CITY OF ALBUQUERQUE

**RE: VISTA DEL RINCON SUBDIVISION aka MARNA LYNN SUBD.
(C-12/D2)
Engineers Certification for Release of Financial Guaranty
Engineers Stamp dated 05/28/2005
Engineers Certification dated 05/10/2005**

Re: Marna Lynn Subdivision Grading and Drainage Plan
Engineer's Stamp dated 4-5-04 (C12/D2)

GRADING PLAN

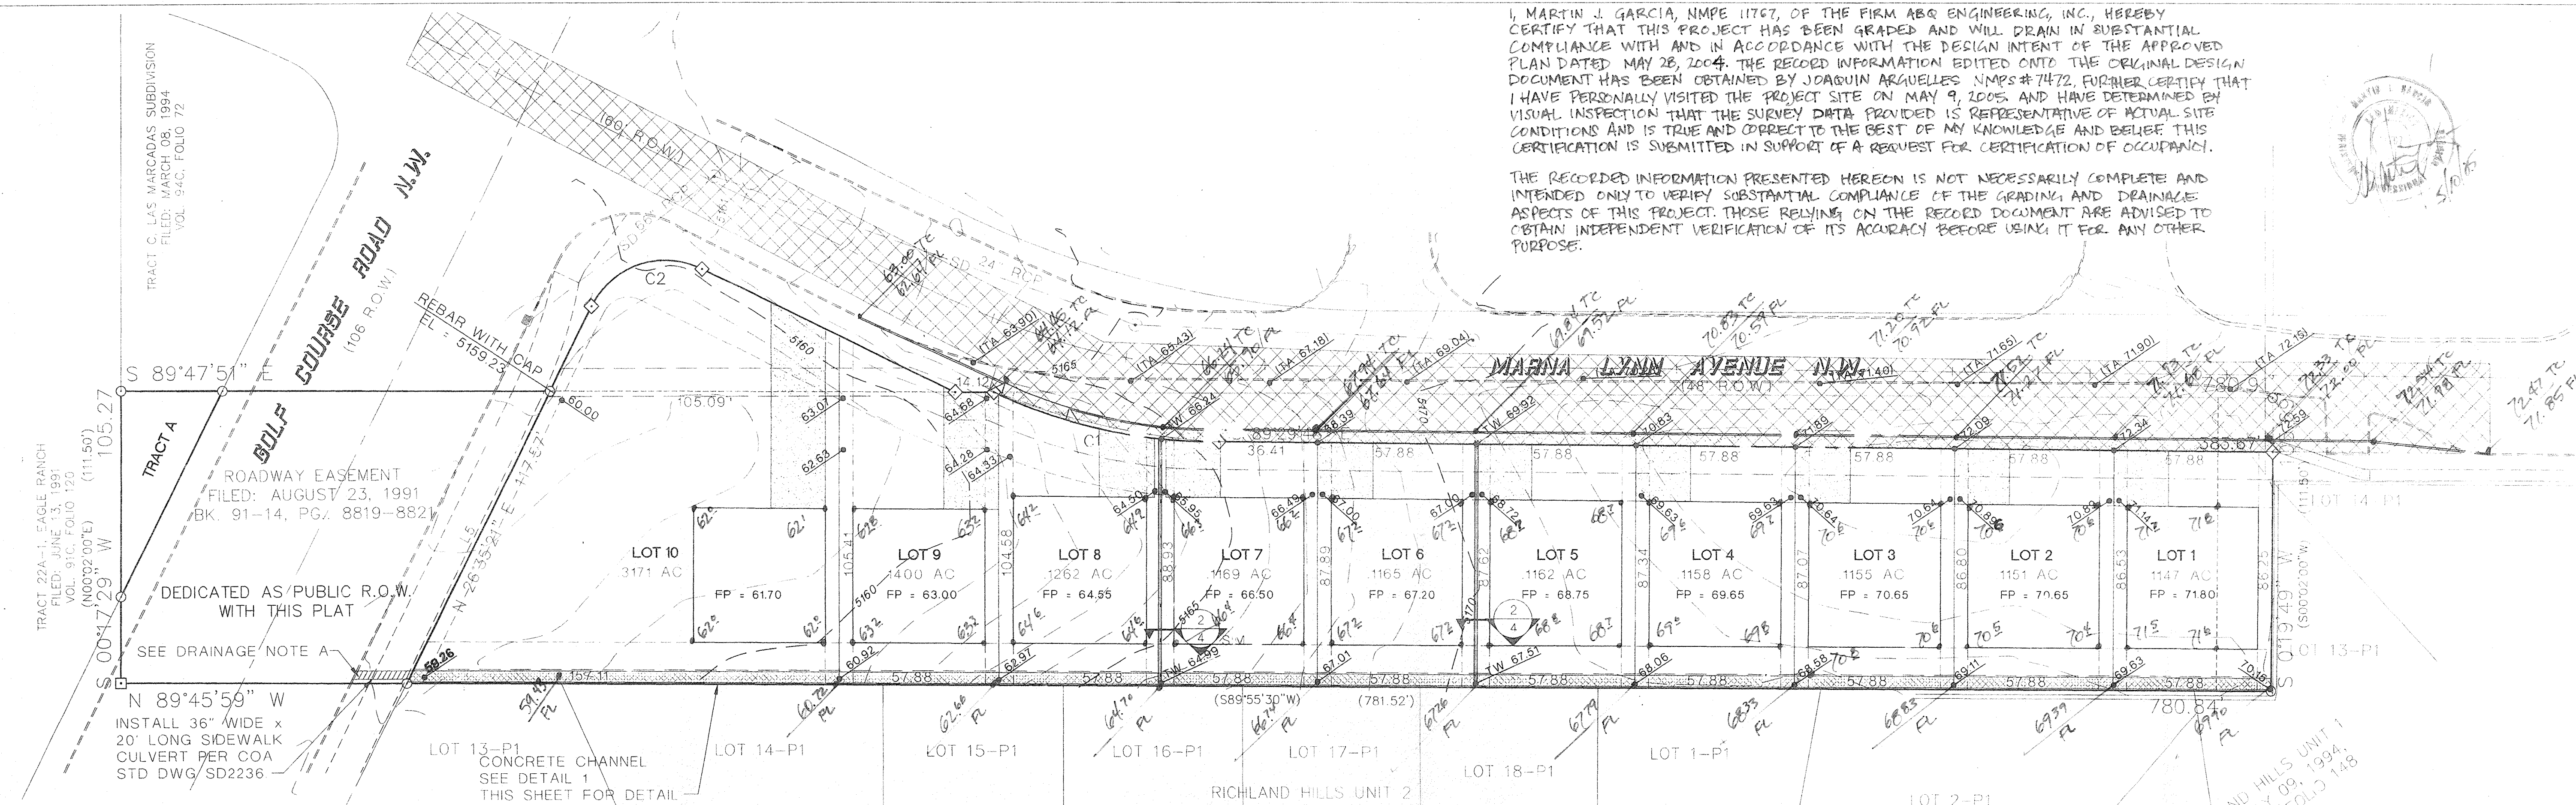
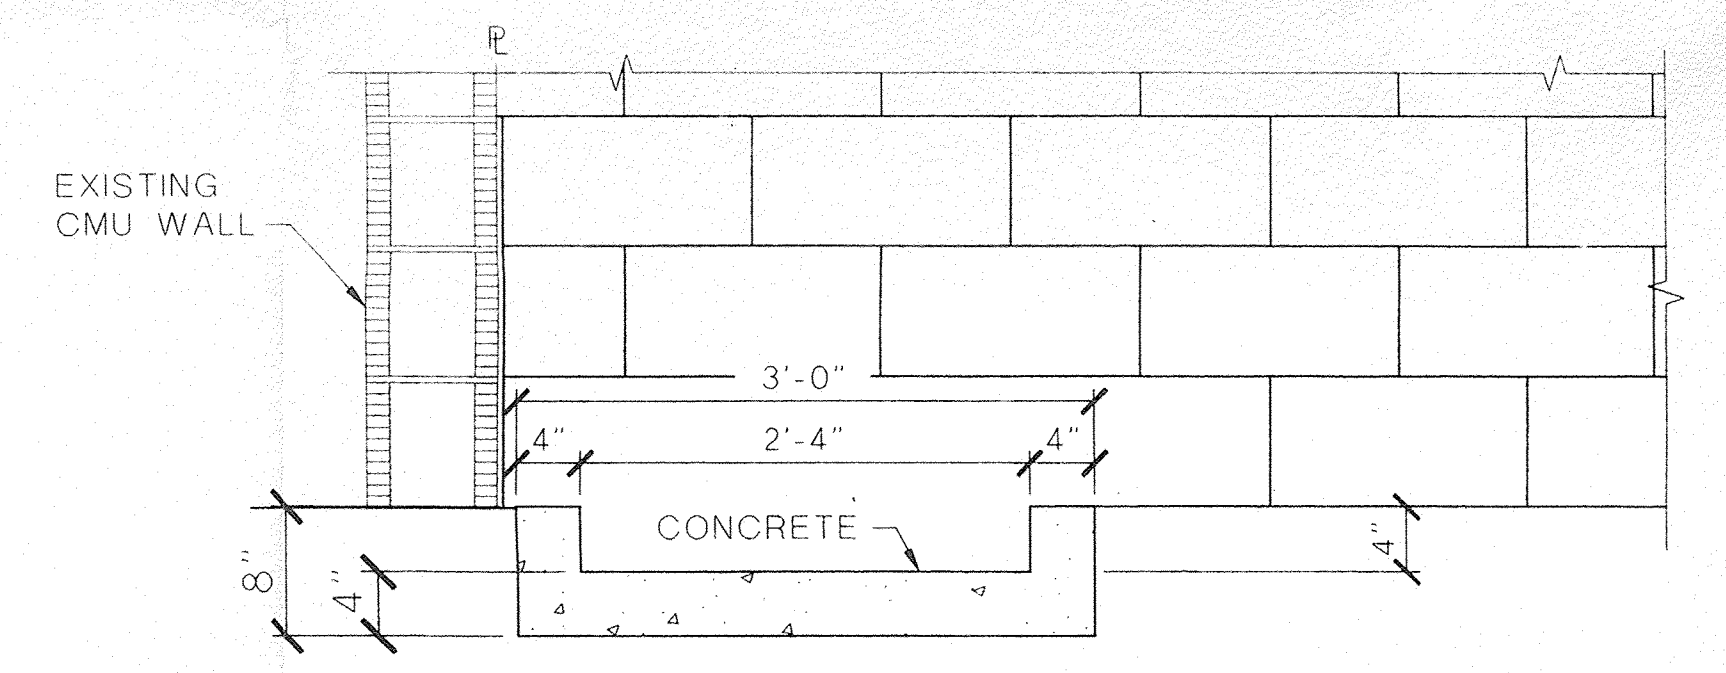
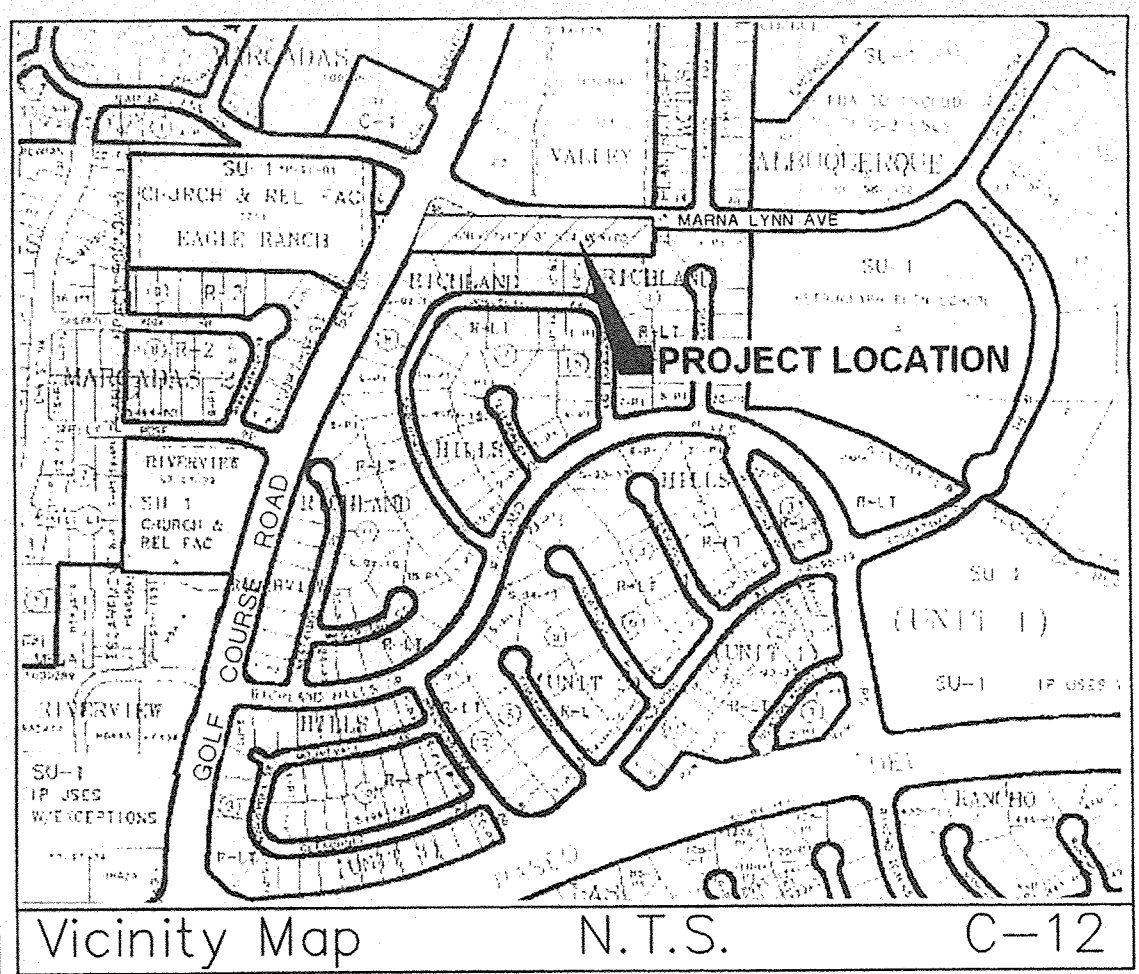
Based upon the information provided in your submittal dated 4-5-04, the above referenced plan is approved for Preliminary Plat action by the DRB. The swale must be concrete and must appear on your infrastructure list. Once that board has approved the plan, please submit a mylar copy for my signature in order to obtain a Grading Permit.
